DRB Application No.: 03DRB-02072 (P&F)	Project # 1003037
Project Name: PEREA ADDITION	EPC Application No.:
Agent: Surveys Southwest LTD	Phone No.: 998-0303

**RE: PEREA ADDITION/sketch**

**CITY OF ALBUQUERQUE  
PLANNING DEPARTMENT  
Development Review Board  
December 17, 2003  
Comments**

**RE: Lots 17-20, Perea Addition**

PLAT OF  
 LOTS 17-A & 19-A, BLOCK 39  
 PEREA ADDITION  
 SITUATE WITHIN SECTION 18,  
 T. 10 N., R. 3 E., N.M.P.M.  
 CITY OF ALBUQUERQUE  
 BERNALILLO COUNTY, NEW MEXICO  
 DECEMBER, 2003

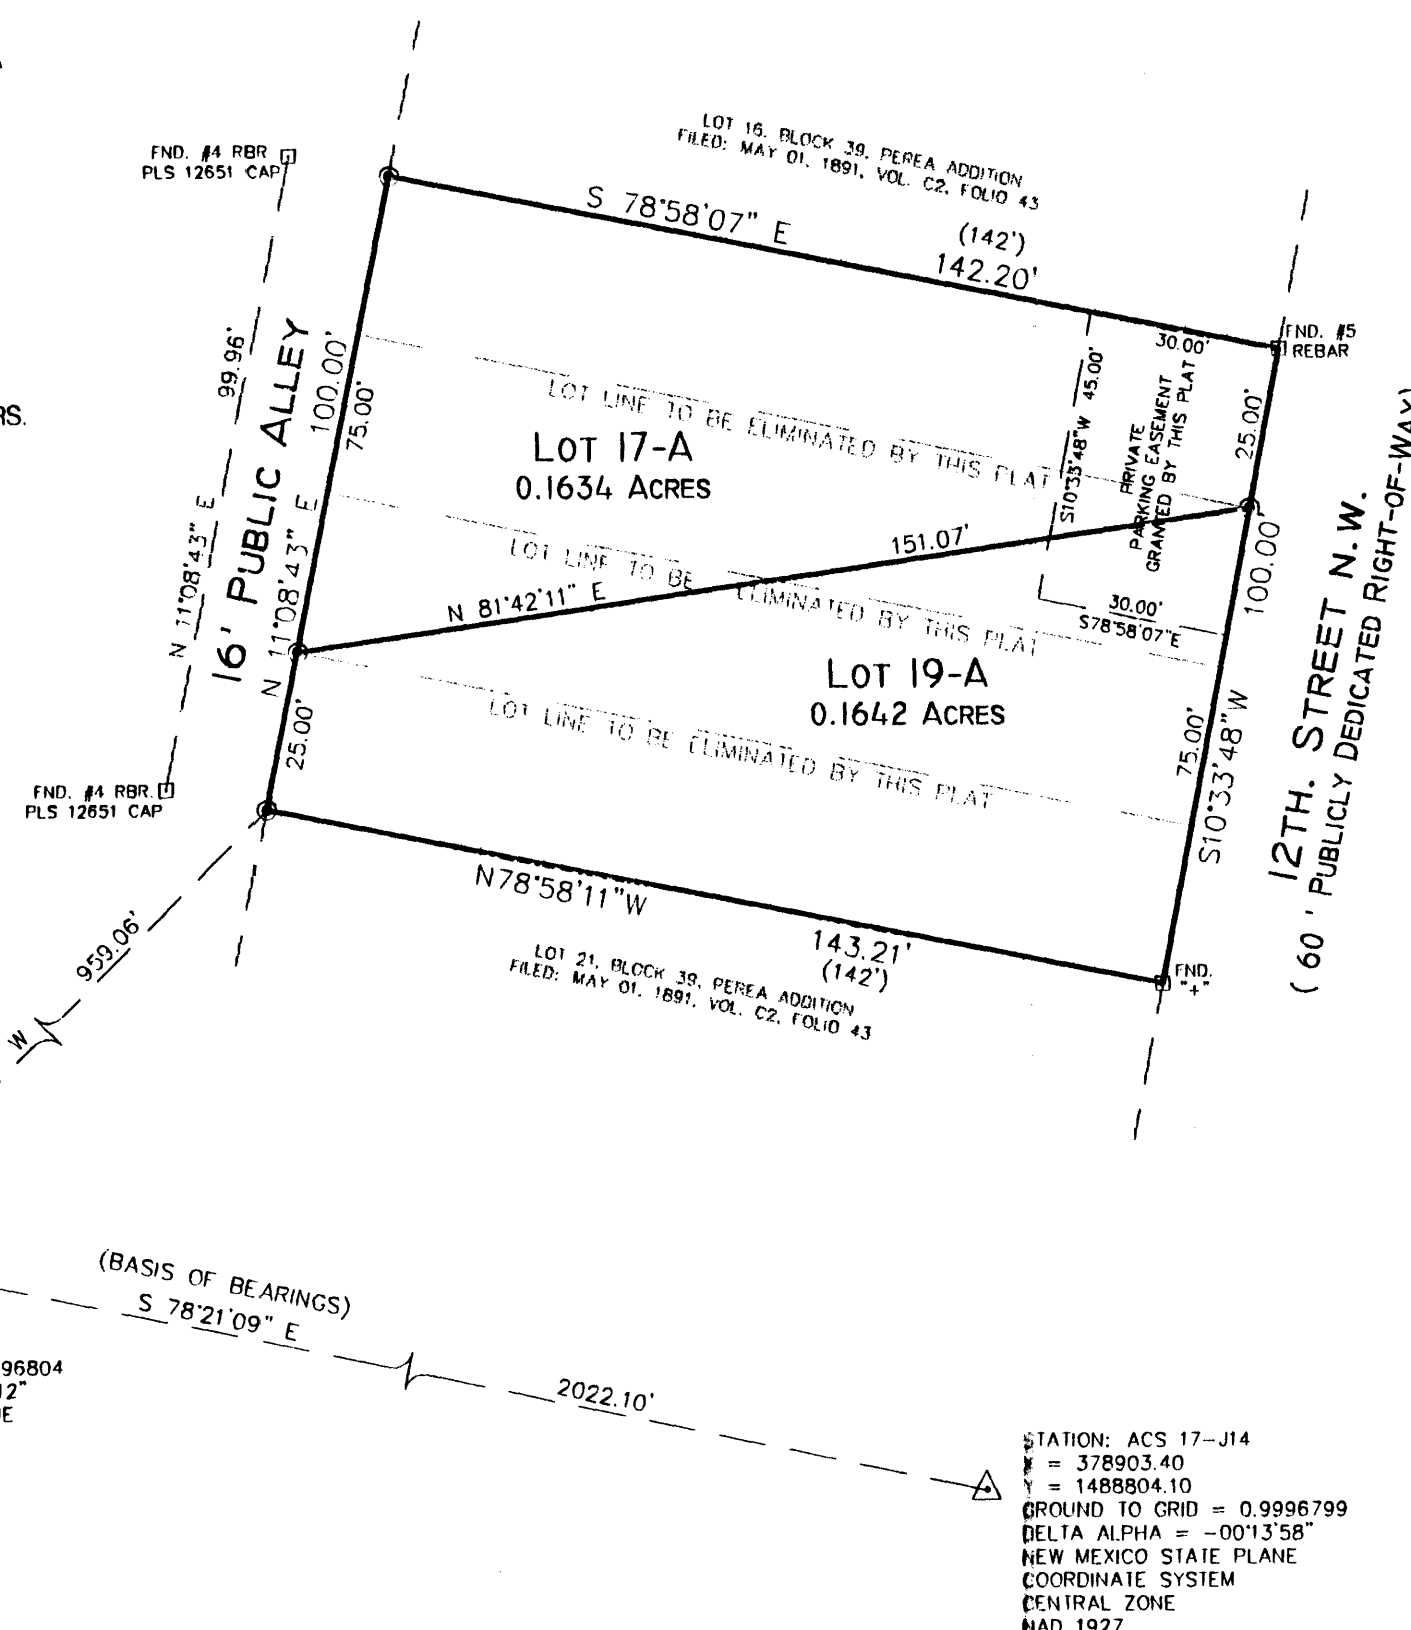
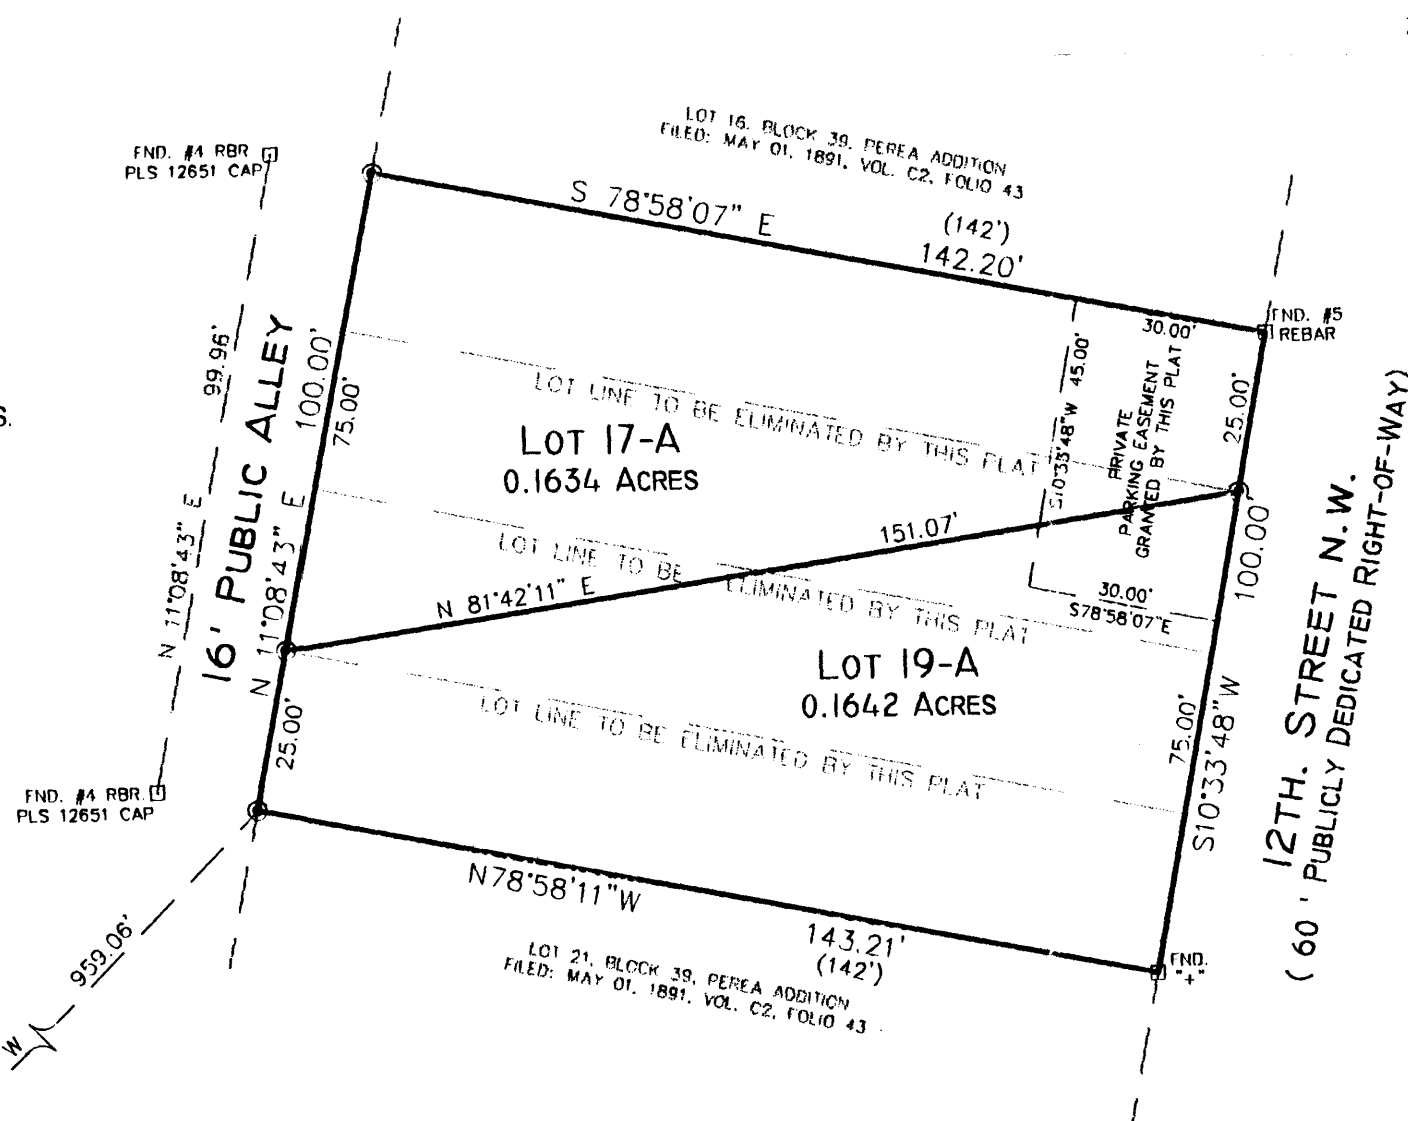
- ① PARKING ACCESS LAYOUT MUSTS TO BE EXECUTED
- ② WILL HOUSES OR LOTS BE SHARING EXISTING CURB CUT?
- ③ WHAT IS WIDTH OF SIDEWALK?
- ④ WILL LOTS BE SHARING ACCESS FROM ALLEY?

Where is the front of each house?

No objection to the requested actions. AGIS dxf is approved. Applicant may file the plat. Please provide a copy of the recorded plat.
